STATE OF NORTH CAROLINA
DEPARTMENT OF TRANSPORTATION

Addendum No. 1

Wake County (U-5315A, U-5315B)

Morrisville Parkway Extension From West Of Highcroft Drive
To East Of Mills Park Drive In Cary

PROJECT REFERENCE NO. U-5315 28/B SHEET NO. 4

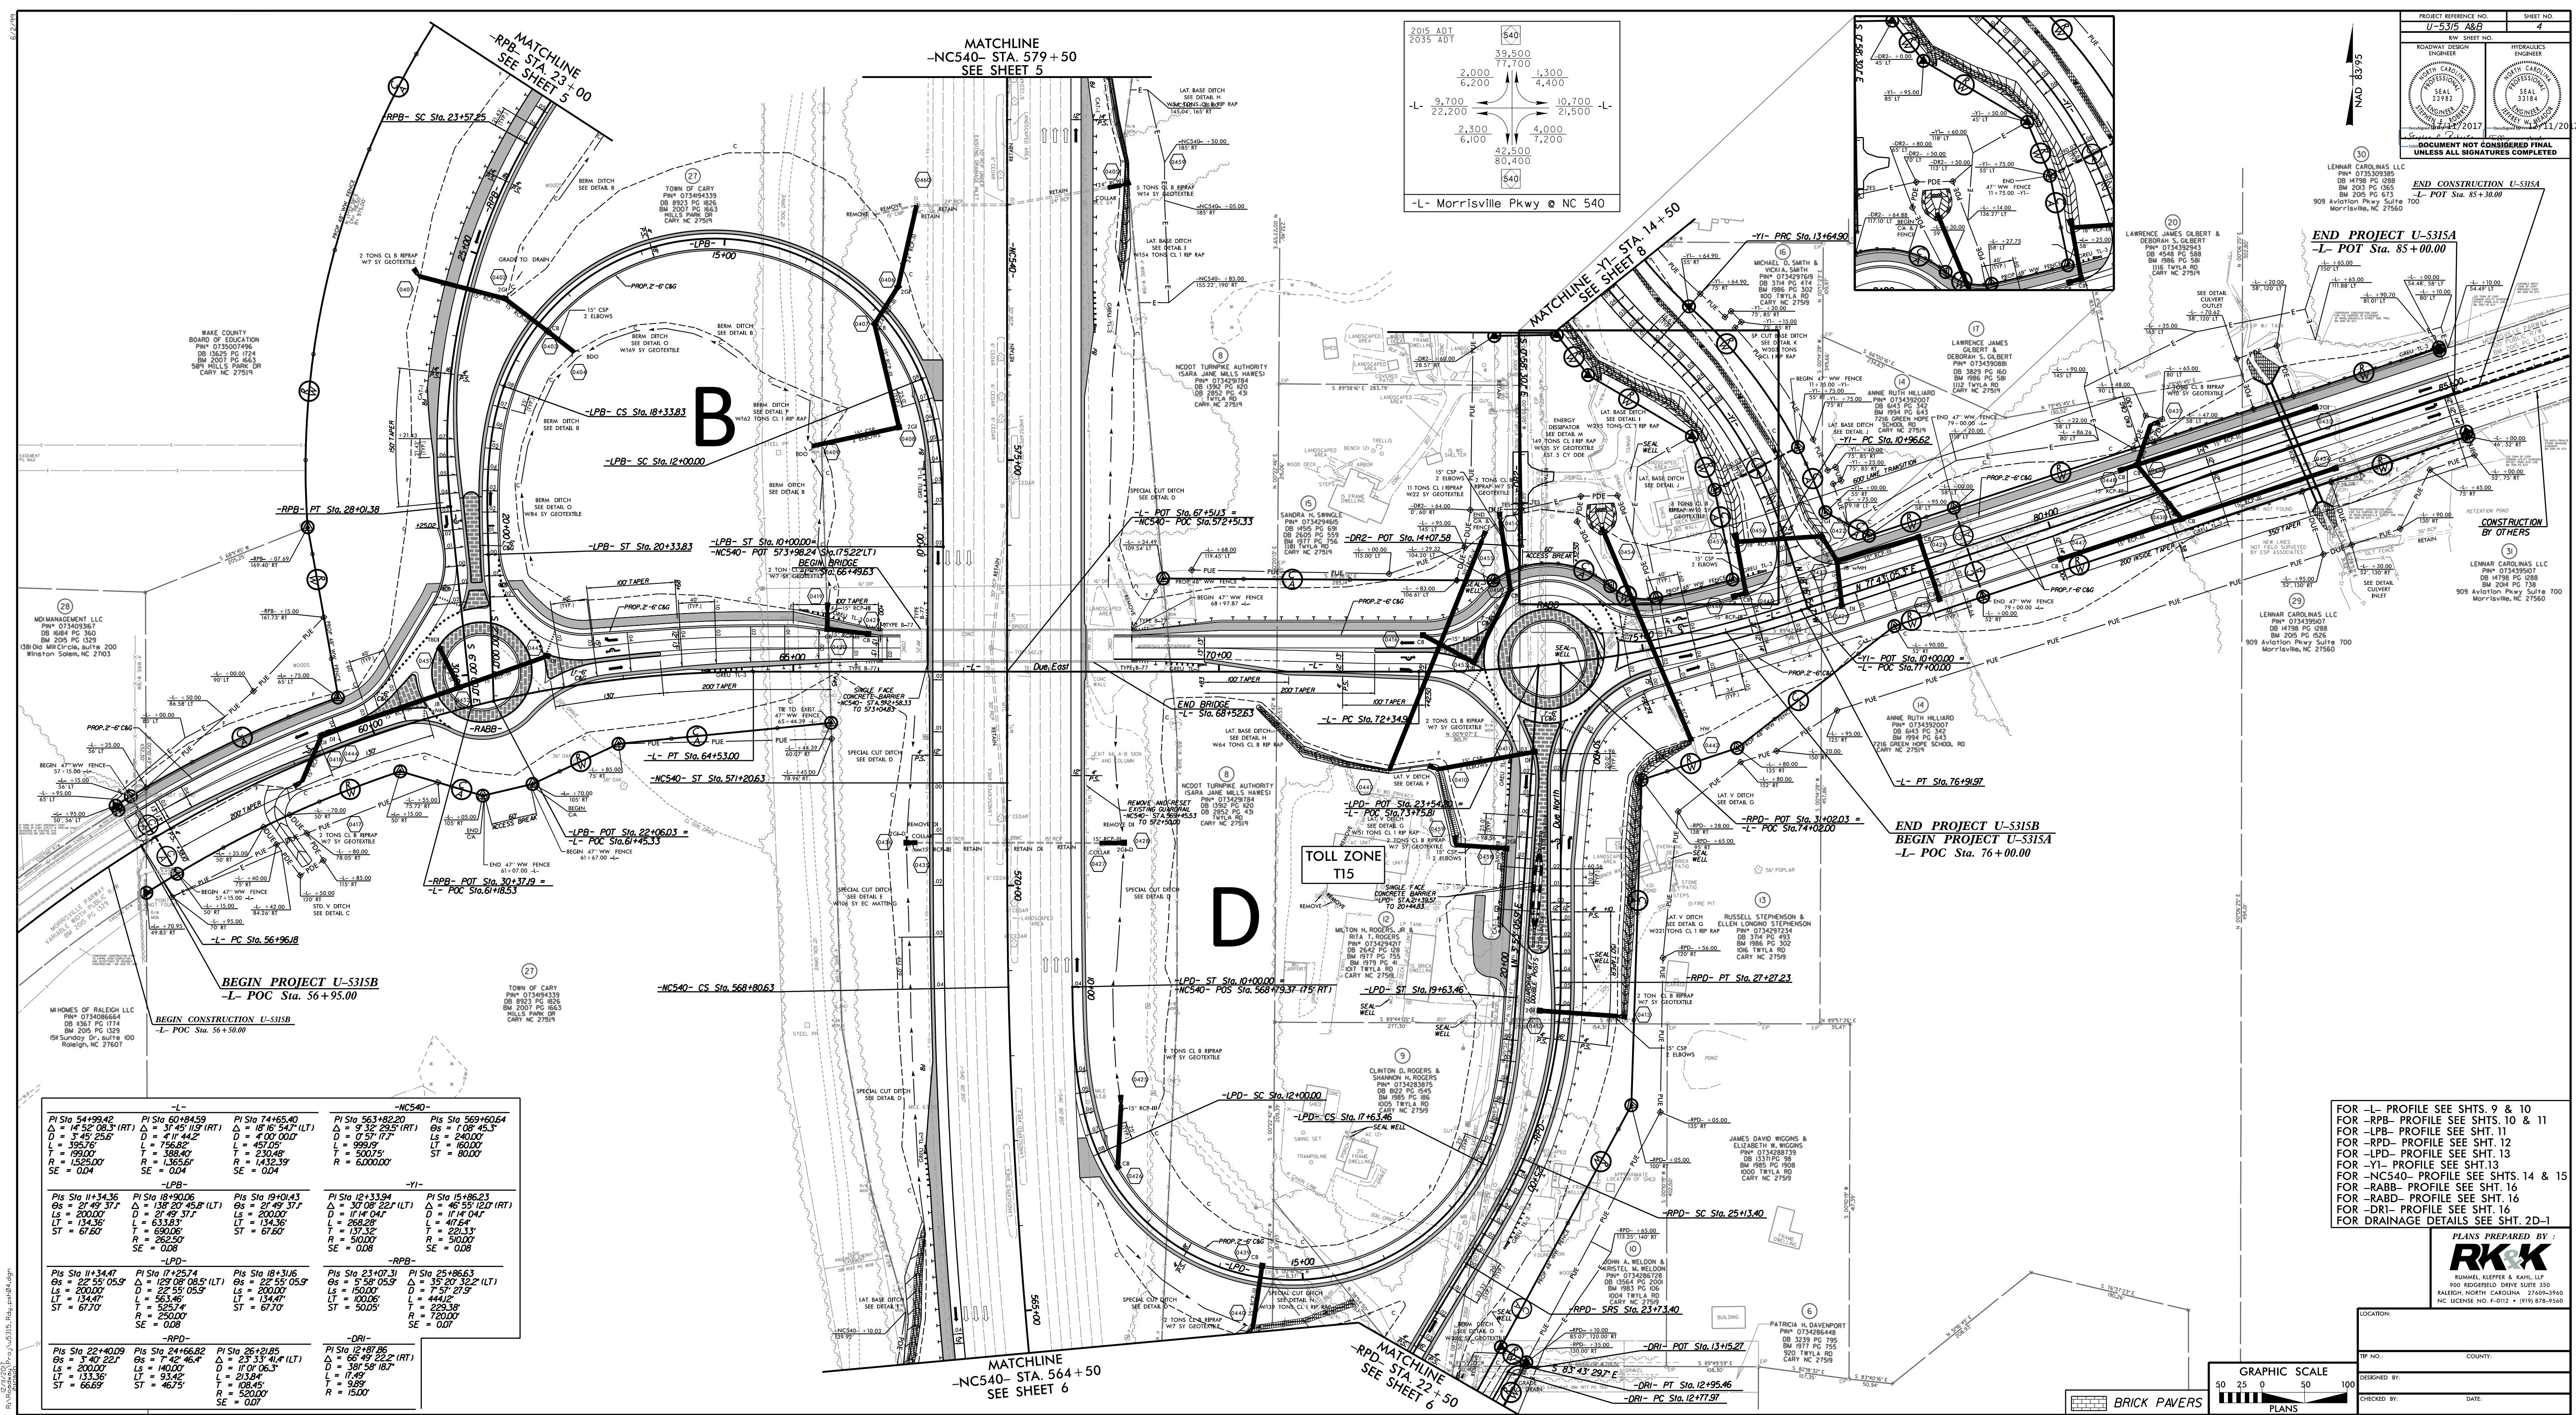
Sheet No.	Revisions
2A-1 and 2A-3	Revised to add "C6" and "D2" to pavement schedule to require the final layer of surface course be 2" thick within the toll sites
3B-2	Revised the 4" and 5" Posts quantities within the "Summary Of Woven Wire Fence, 47" Fabric"
4	Revised Guardrail and Sidewalk tie-in location at bridge
5	Change gate to 12' width within the Right Of Way fence at Sta. 13+85 -RPB-
TMP-2	Added Step 6A which directs the Contractor to fill the existing rumble strips along NC 540
SIGN-02A	Updated Summary Of Quantities Table
SIGN-02B	Revised Signs 201 and 202 to use Omni-Coupler breakaway supports

ITS-14	Removed splice components for RWIS on splice detail
X-3	Revised cross-sections for Stations 64+00 thru 65+00 to reflect the change to guardrail from revised Plan Sheet 4
New S-1 thru S-3	New sheets added to include details/requirements for sidewalk to be constructed on the existing bridge
